This report describes a Stage 1 Road Safety Audit carried out on the proposed access arrangements for a new 280,000m² employment development on land adjacent to the M40 J10. Two access points (eastern and western) will be provided either side of the A43 / B4100 Baynards Green roundabout junction. This audit report considers the eastern access.

It is confirmed that this is a Stage 1 Road Safety Audit and that the audit was undertaken upon completion of the preliminary design work.

This audit considers the proposed provision of a new roundabout junction on the B4100 east of the A43 tying into the pre-Growth Fund (existing) highway arrangement.

JOB TITLE		M40 JUNCTION 10		CLIENT		ALBION LAND	
DRAWING TITLE							
EASTERN ACCESS PRE-GROWTH FUND							
SCALE	DRAWN BY	DATE	DRAWING No	REVISION			
1: 250@A1		03/08/21	17213-16

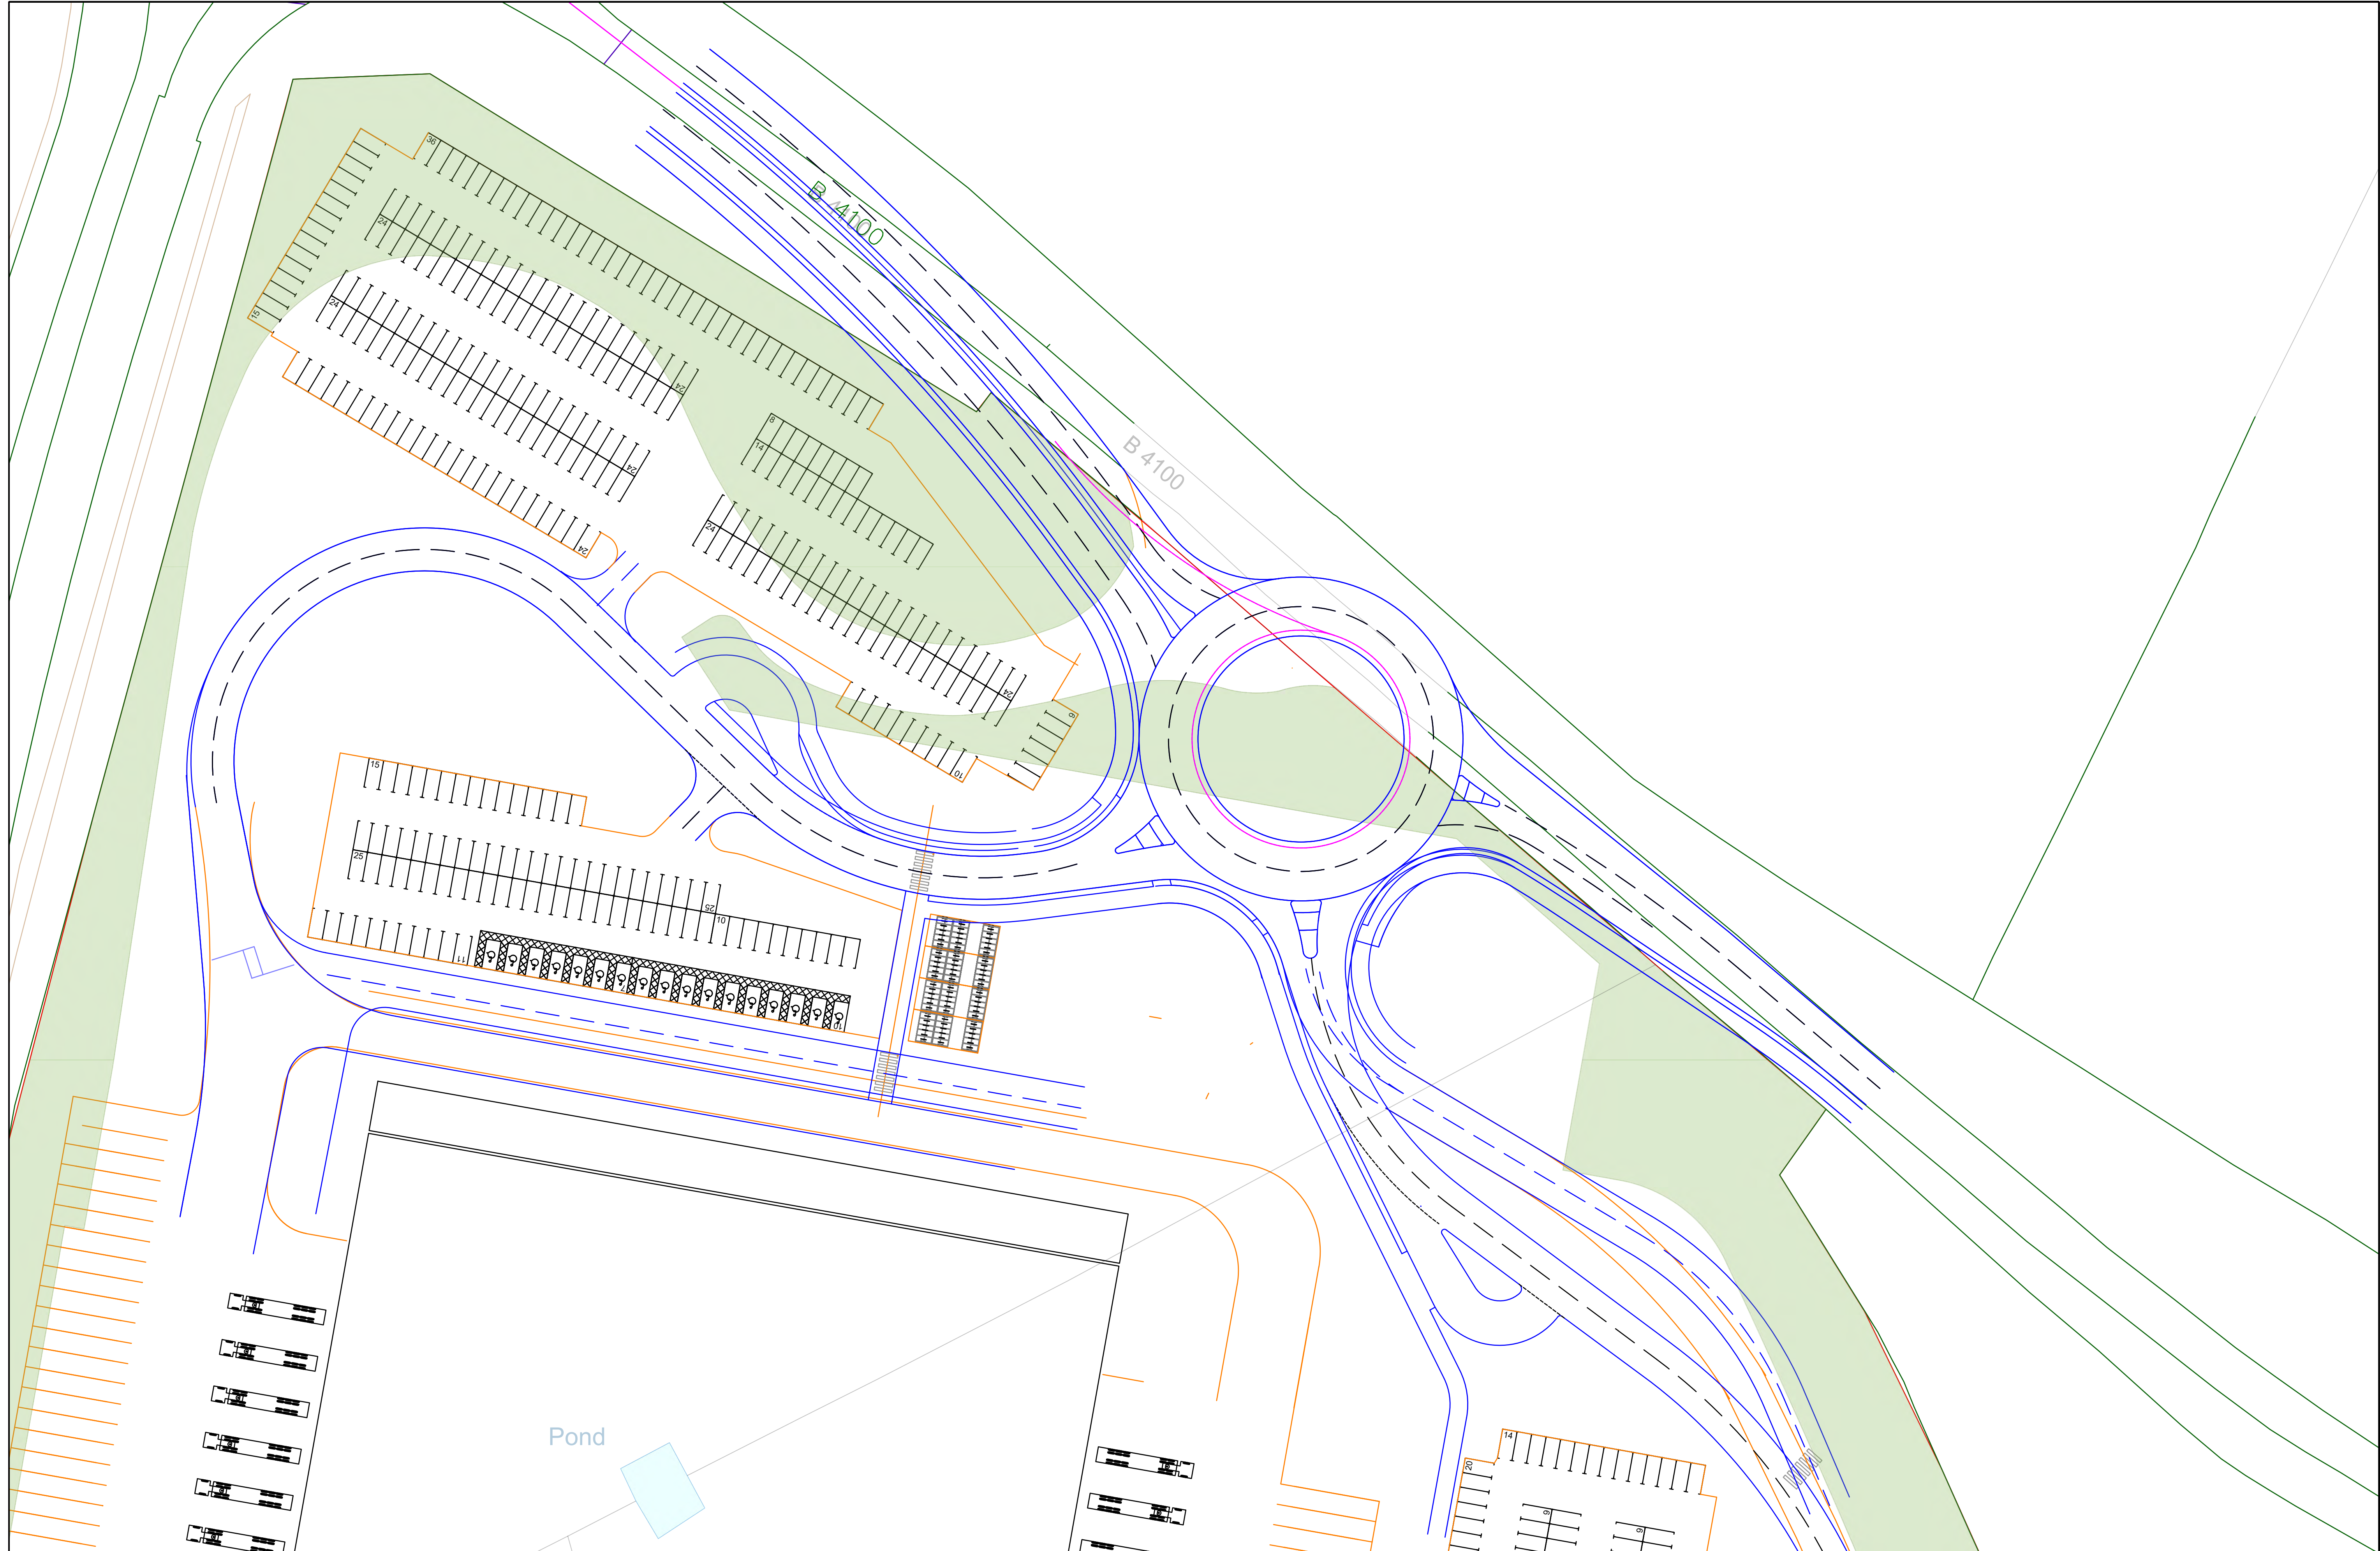
Location: B4100 Roundabout junction.

Summary: Unclear lighting provision may lead to loss of control collisions.

The proposed roundabout junction is in close proximity to the existing A43 Baynards Green junction where street lighting is present. It is not clear from the information submitted if it is intended to light the proposed roundabout. The existing street lighting extends to the tie-in between the new and existing highway. Failure to light the new roundabout will result in south-eastbound motorists transitioning from lit to unlit on the immediate approach to the junction. This may result in motorists misjudging the position or geometry of the roundabout during the hours of darkness, increasing the risk of loss of control type collisions.

It is recommended that the proposed roundabout is lit and that the lighting appropriately ties-in with the existing street lighting.

## B. Location Plan – Eastern Access (pre-Growth Fund)

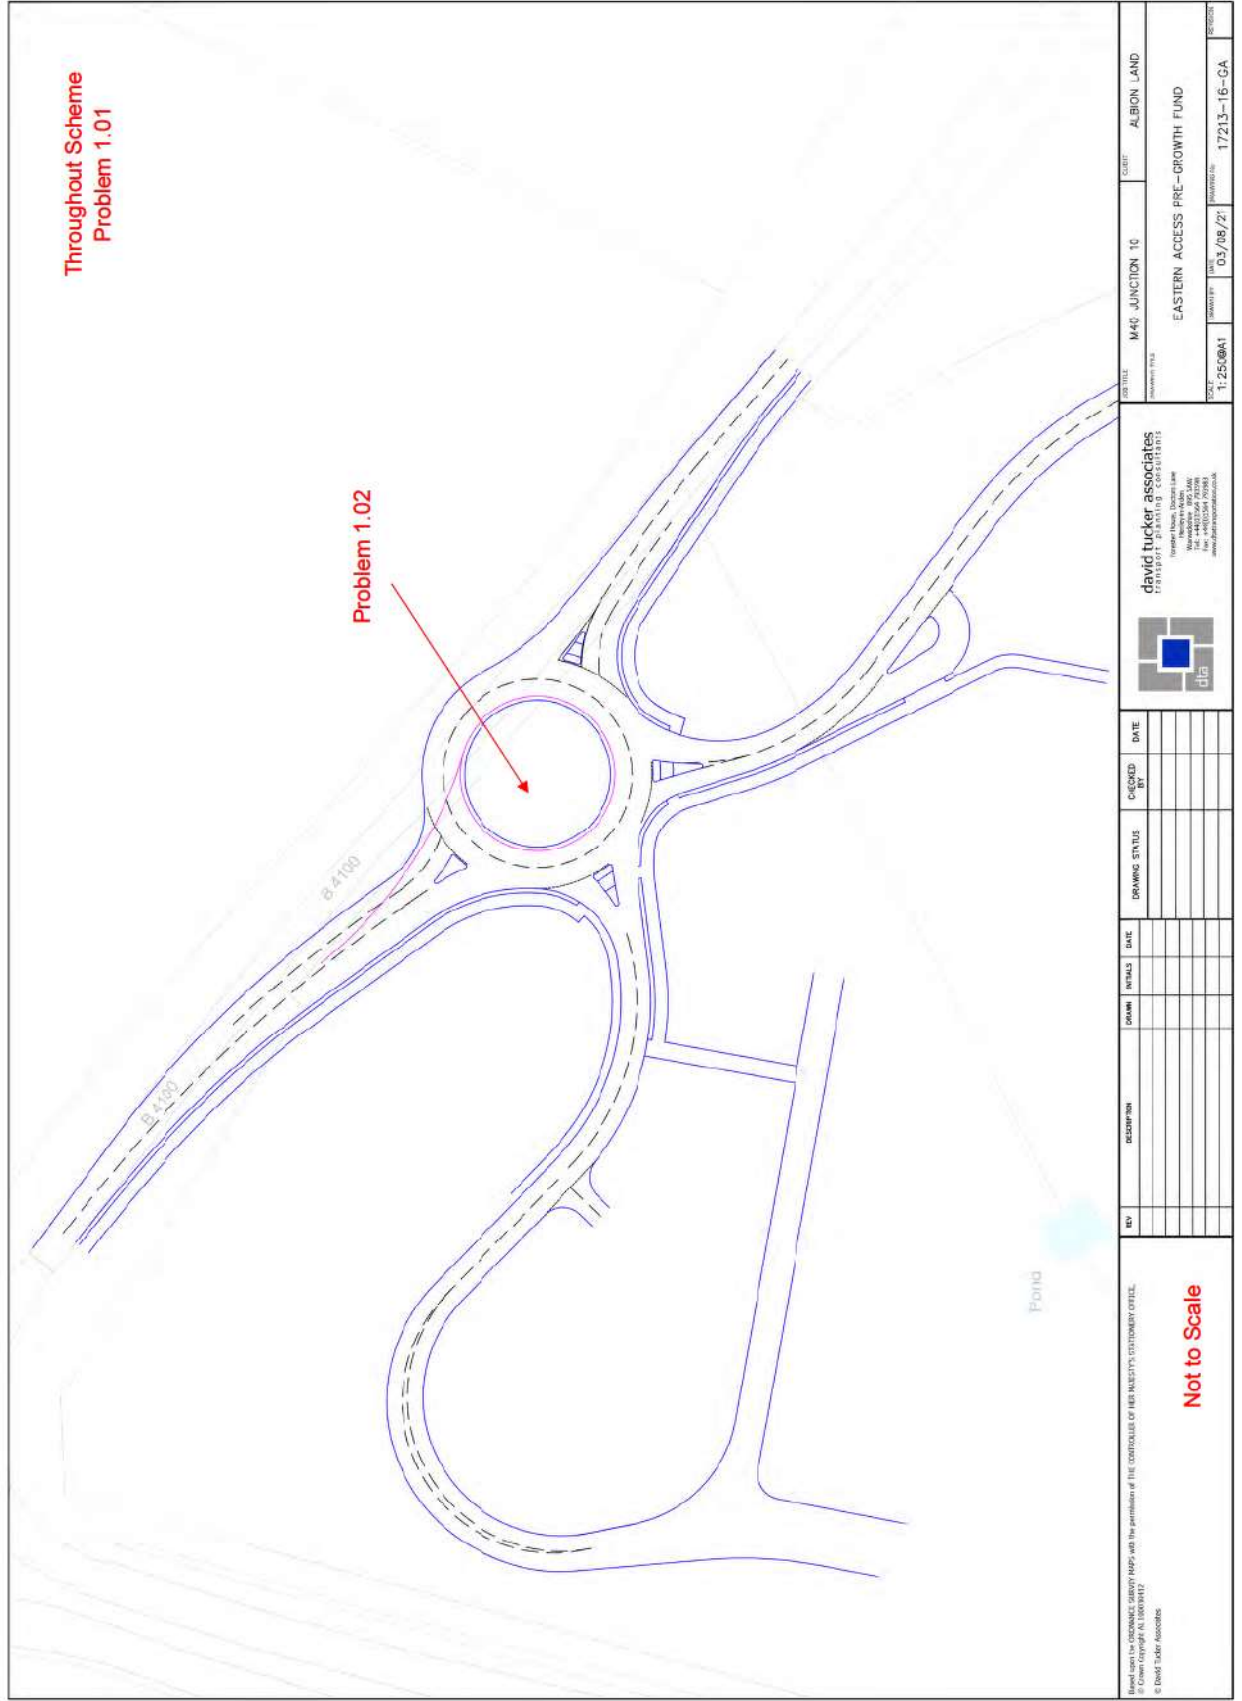
Location: Throughout Scheme.

Summary: Unclear impact of additional traffic on surrounding highway network.

The proposed development and its eastern access are in close proximity to the A43 Baynards Green roundabout. At present, no junction appraisals have been undertaken therefore it is not possible to consider the impact that this development will have on the local highway network and particularly the A43 junction. Should the junction fail to accommodate the increase in traffic, and particularly HGVs, there is an increased risk of rear end shunt or side impact type collisions associated with inappropriate turning manoeuvres resulting from driver frustration / impatience.

It is recommended that traffic modelling is undertaken to assess the impact that the proposed development will have on the surrounding highway network, and particularly the A43 Baynards Green roundabout.
